From: Anita Gardner <Anita.Gardner@arun.gov.uk>
Sent: 27 April 2021 09:23
To: Planning.Responses <Planning.Responses@arun.gov.uk>
Subject: FW: AB/39/21/DOC - 19 Maltravers Street, Arundel

I am e-mailing you in respect of the above approval of details reserved by condition imposed under ref AB/125/20/L relating to Condition Nos 3 - details of junction between elevation of extension & flat roof including materials, 4 - materials & finishes for brick & brick bond, 5 - details of new external door including materials, finish & method of glazing, 6 - materials & finishes for rooflight and 7 - details of internal window including proposed glazing

Section A-A

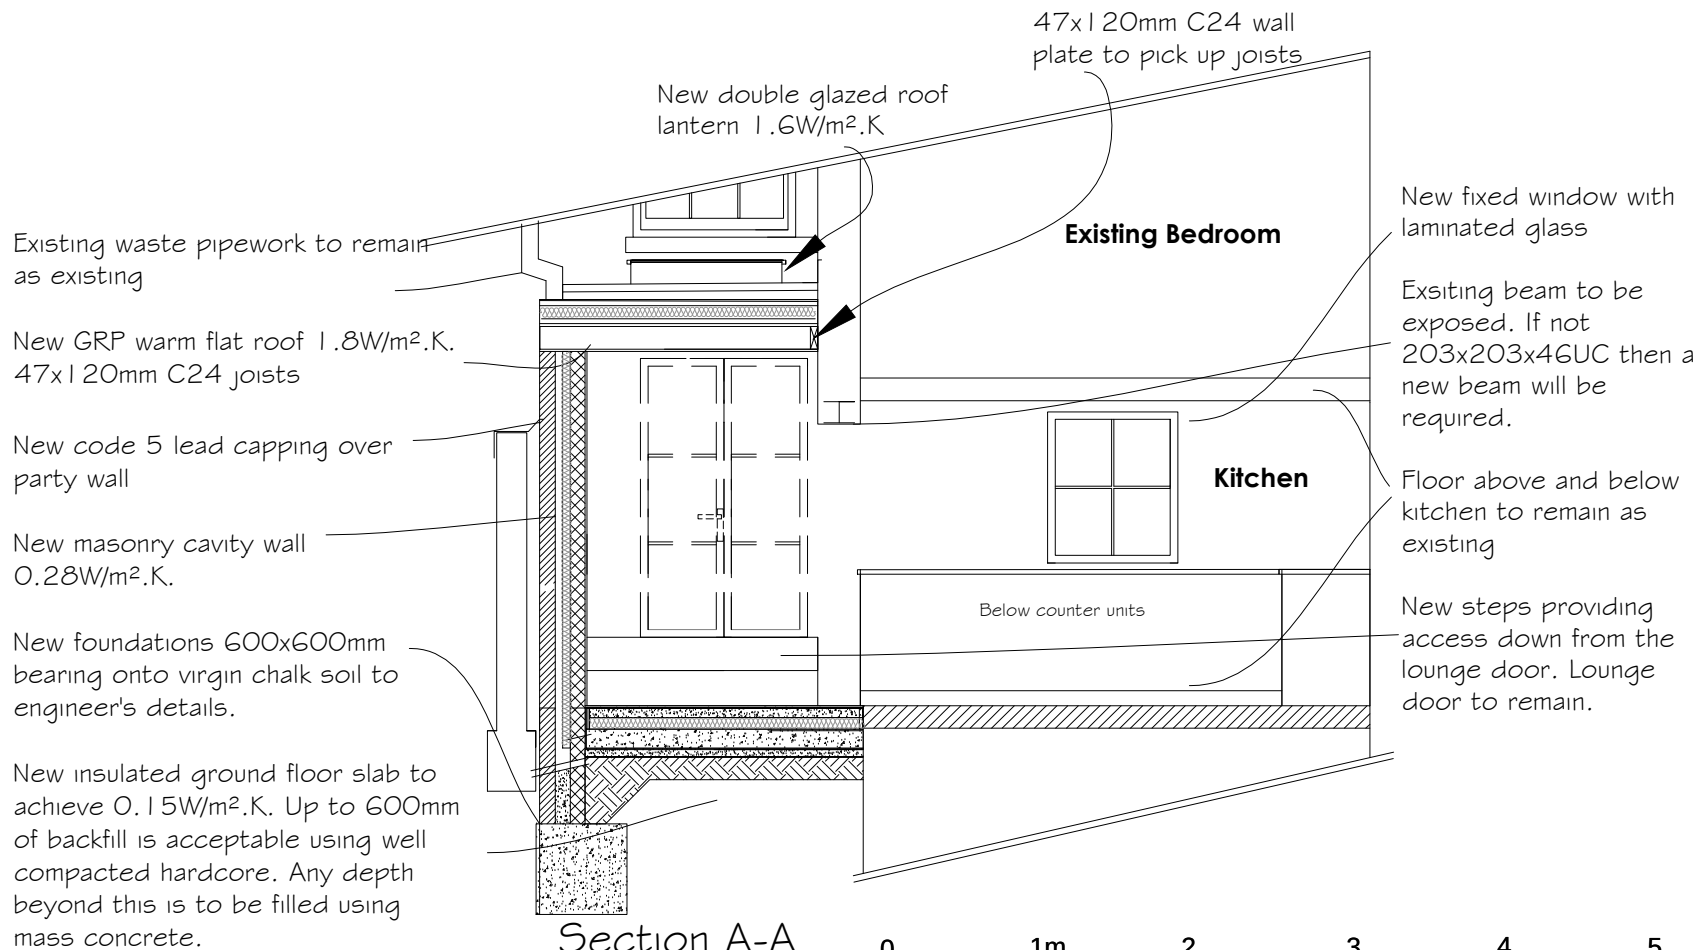
In respect of condition 7 it would help to have further information regarding the interior window: what will the glazing bars look like? Will they be integral or applied to the frame?

I also note that the intention is to revise the treatment of the small areas either side of the rear elevation door from brick to render and use the same paint colour as already present on the listed building. Whilst this approach is likely to be acceptable, it can't be submitted as discharge of condition application since the treatment of the wall was detailed on the approved plans and there are no conditions relating to submission of render for approval. In order to make this change a new application for Listed Building Consent will need to be submitted for consideration.

The window will be joinery quality timber construction with laminated glass. The parting beads will be timber bevelled to match the sash detail to the front of the property.

My client will continue with the facing masonry as shown on the application. There is a miss match (3 different types of brick) across the rear elevation. They plan on using a darker brick to the upper parts of the addition. See photos attached. A brick in similar style and appearance as a Wienerberger Cassandra multi stock will be used. Owing to the small amount of facing brickwork, it would be best to lay in a stretcher bond but are happy to consider a Flemish bond if that is your preference.
